WEST SUSSEX COUNTY COUNCIL CONSULTATION

TO:	Arun District Council FAO: Amber Willard
FROM:	WSSC - Highways Authority
DATE:	30 June 2022
LOCATION:	25 Pevensey Road, Bognor Regis, PO21 5NS
SUBJECT:	BR/124/22/HH First floor side extension, barn end to gable end roof extension with 2 x side dormers and installation of crossover.
DATE OF SITE VISIT:	N/A
RECOMMENDATION:	Advice
S106 CONTRIBUTION TOTAL:	N/A

DRAWING TITLE
FRONTAGE PARKING AND CROSSOVER

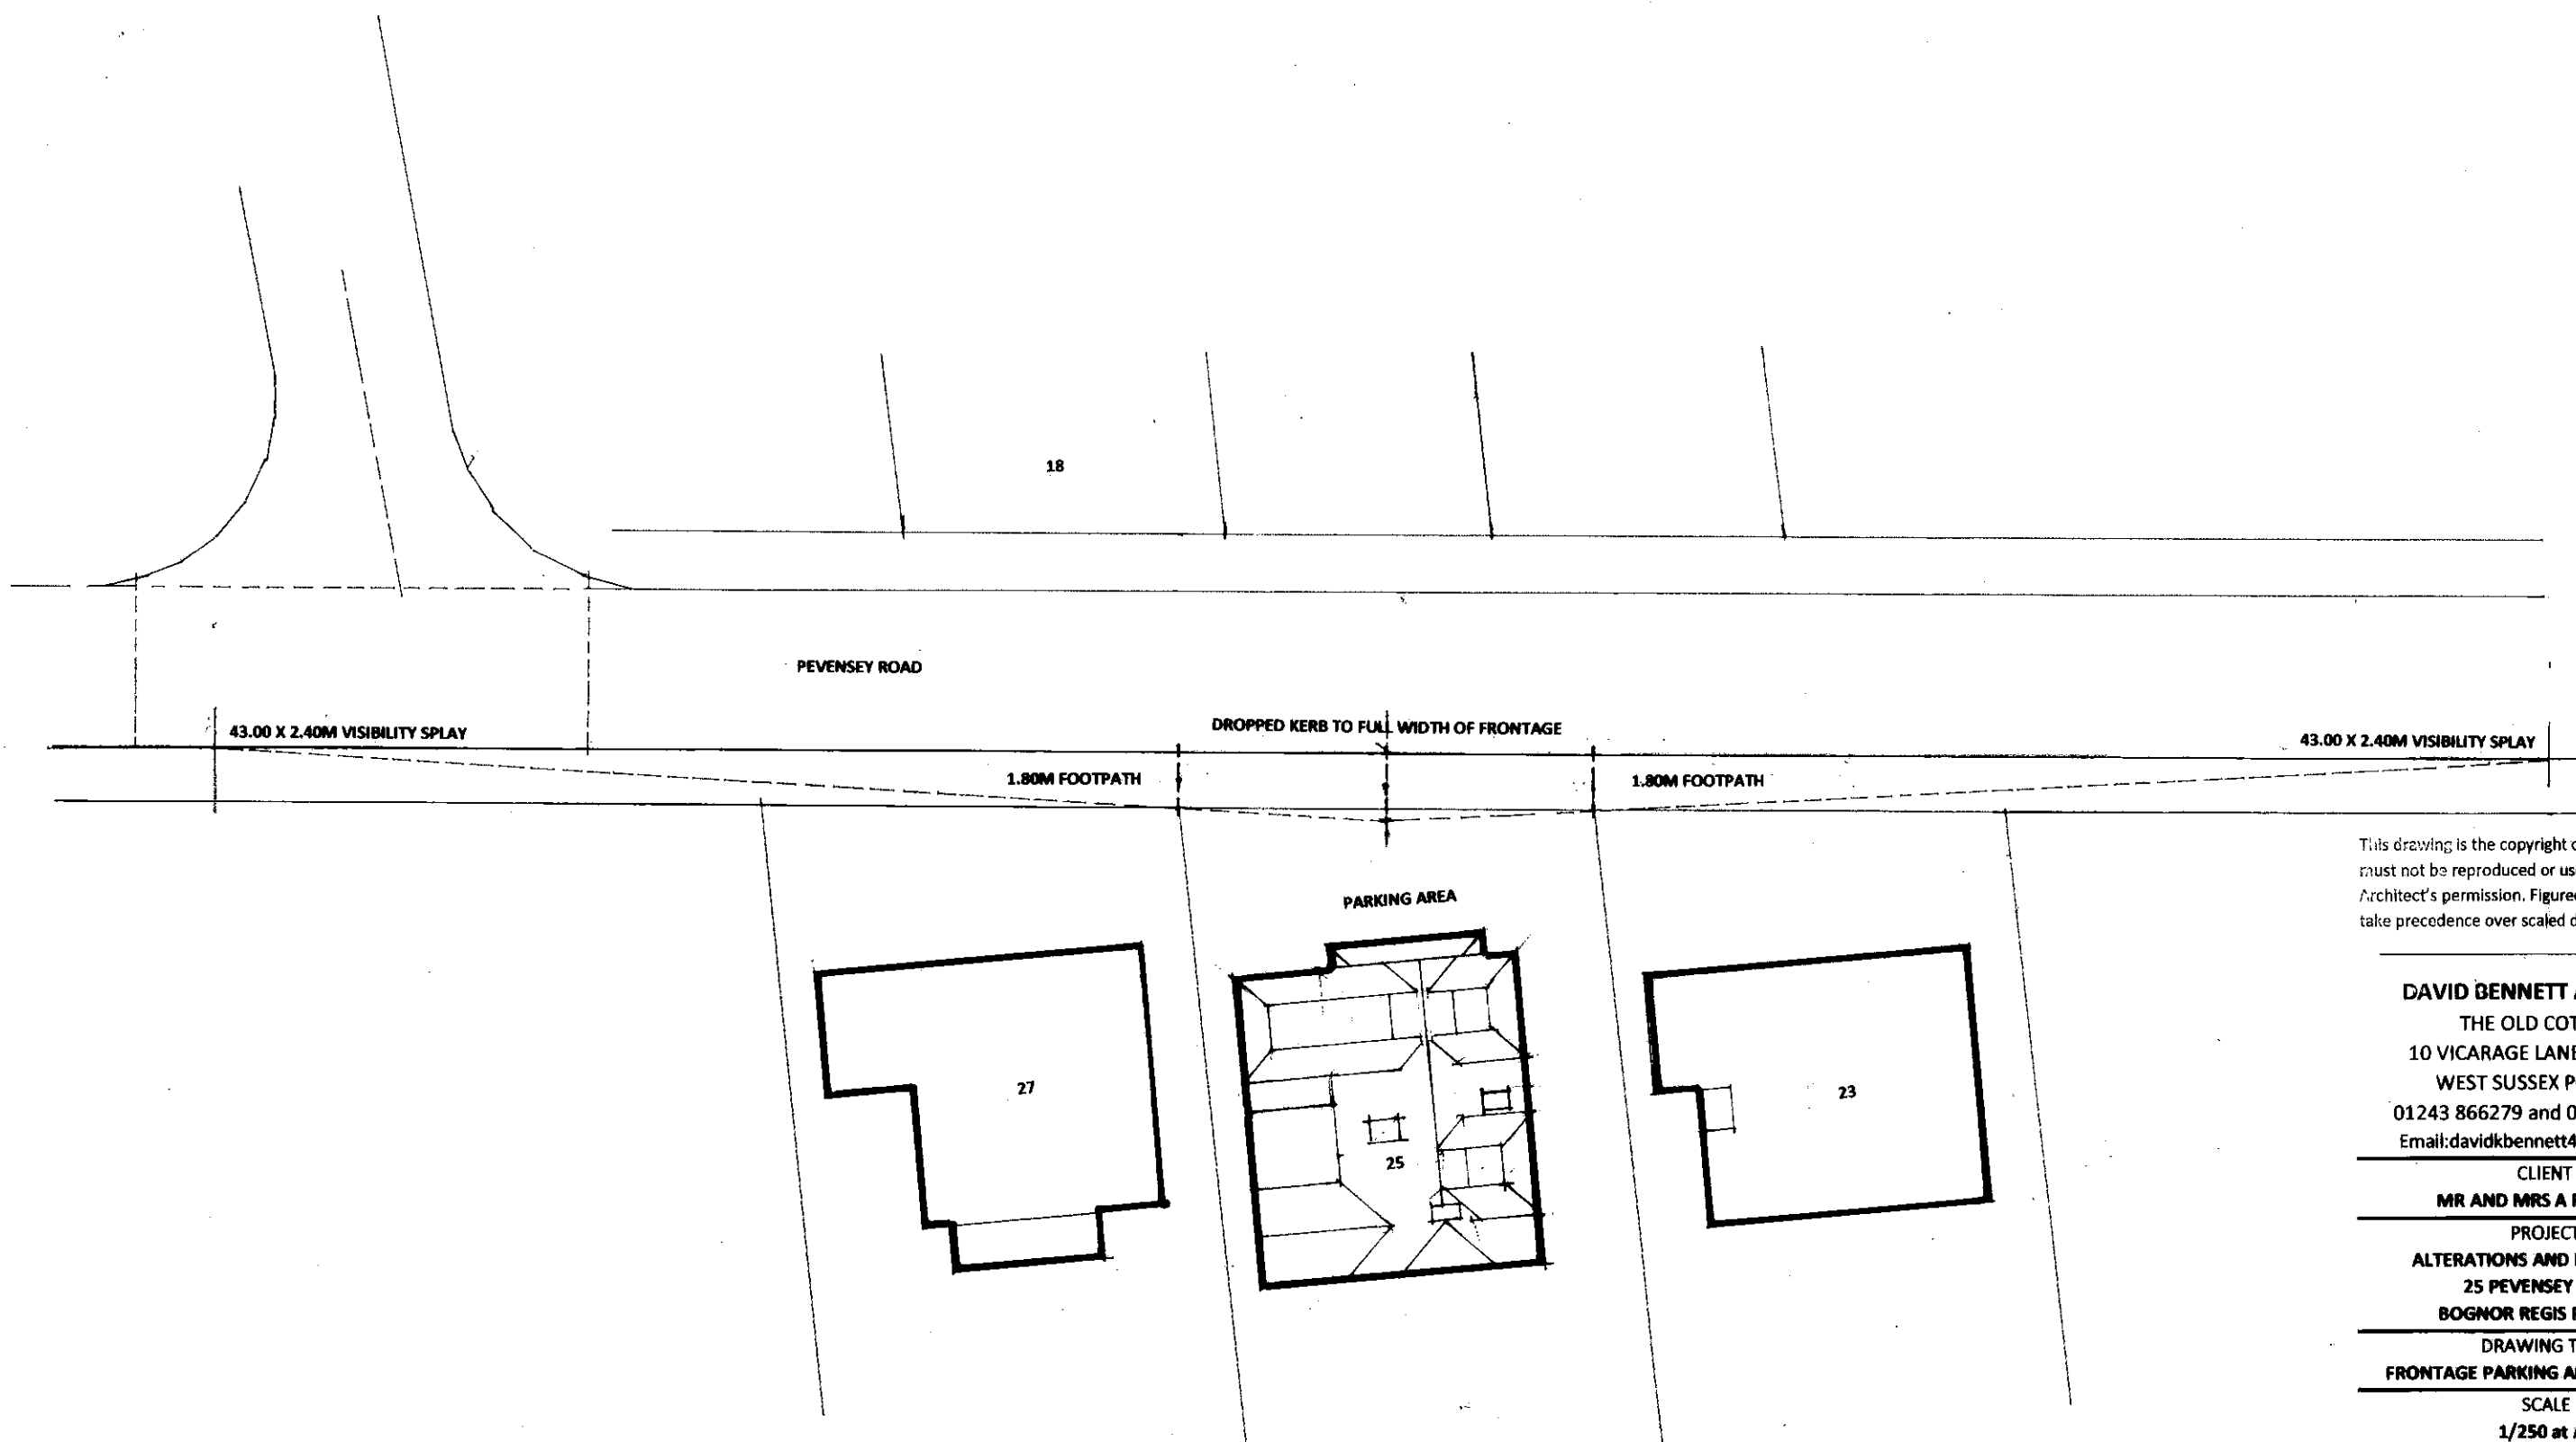
Regarding access, the applicant proposes to drop the entire kerb fronting the property, providing an approximate 15m wide VCO. The applicant has demonstrated suitable visibility splays for the proposed point of access on to Pevensey Road.

The proposed access works will be subject to a licence obtained through the local Highway Area office and constructed to a specification agreed with the local Highway Area Engineer. The applicant should be made aware that under current Area Office guidance, the maximum permitted width for a VCO is 6.4m. As the proposals include a widening to 15m, the proposed access works are unlikely to be granted a licence and therefore, the applicant is advised to reduce the access width to at least 6.4m prior to applying for a VCO licence.

In addition, parts of the site frontage are below the minimum required depth of 4.8m. The plans demonstrate a car parking space positioned parallel to the edge of the highway. Typically, car parking spaces should be positioned perpendicular to the

highway and as such, further dialogue with the Area Office may be required regarding this also.

However as mentioned above, some elements of the proposed VCO are contrary to current Area Office guidance and as such, may not be granted a licence. The applicant is advised to contact the local Highway Area Office to gauge the suitability of the access proposals.
